BN/24/13/NMA

Application for a non-material amendment following a grant of planning permission.

Application for a non material amendment following a grant of planning permission BN/24/10/ for window changes to west elevation, additional window above porch, reduced size window (top left), addition of new roof per plan and window on west elevation.

PROPOSED GROUND FLOOR

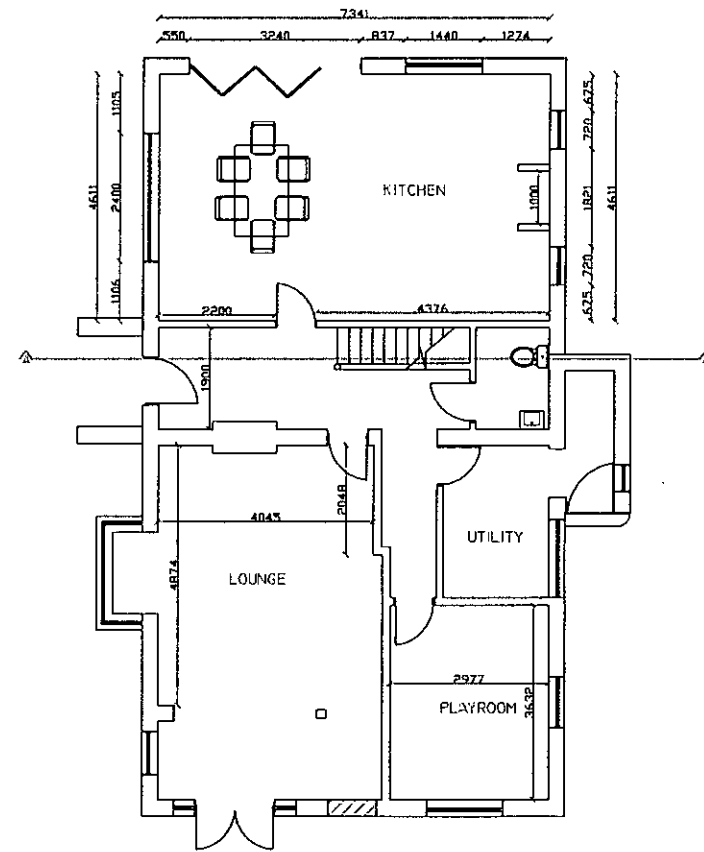
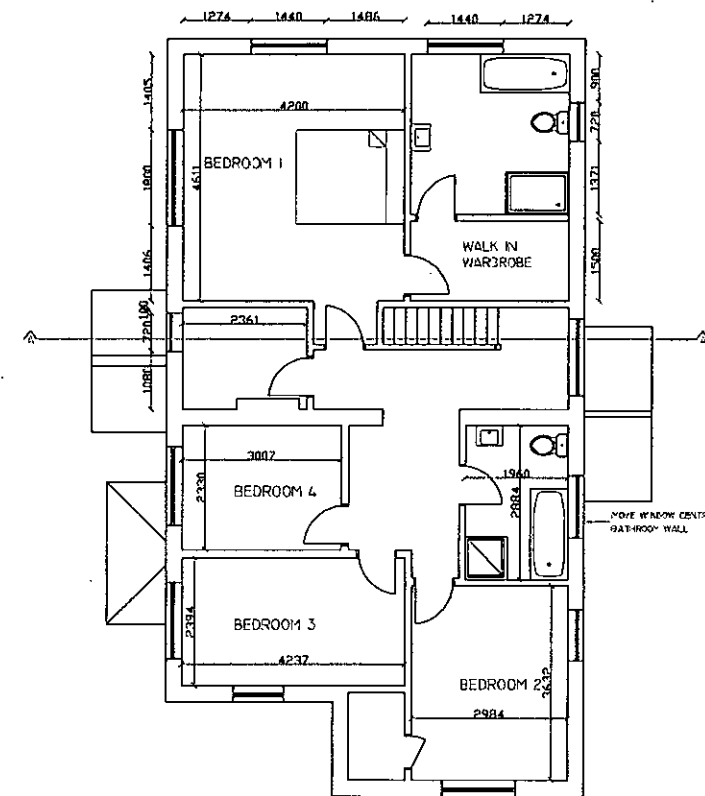
WINDOW CHANGES TO WEST ELEVATION. ADDITIONAL WINDOW ABOVE PORCH. REDUCED SIZE WINDOW (TOP LEFT).

EXISTING SOUTH / WEST SECTION TO BE RETAINED ~~AS~~ AS PER ORIGINAL. ADDITION OF NEW ROOF AS PER PLAN. WINDOW ON WEST ELEVATION.

NO LONGER WISH TO REMOVE & ORIGINAL SOUTH / WEST SECTION.
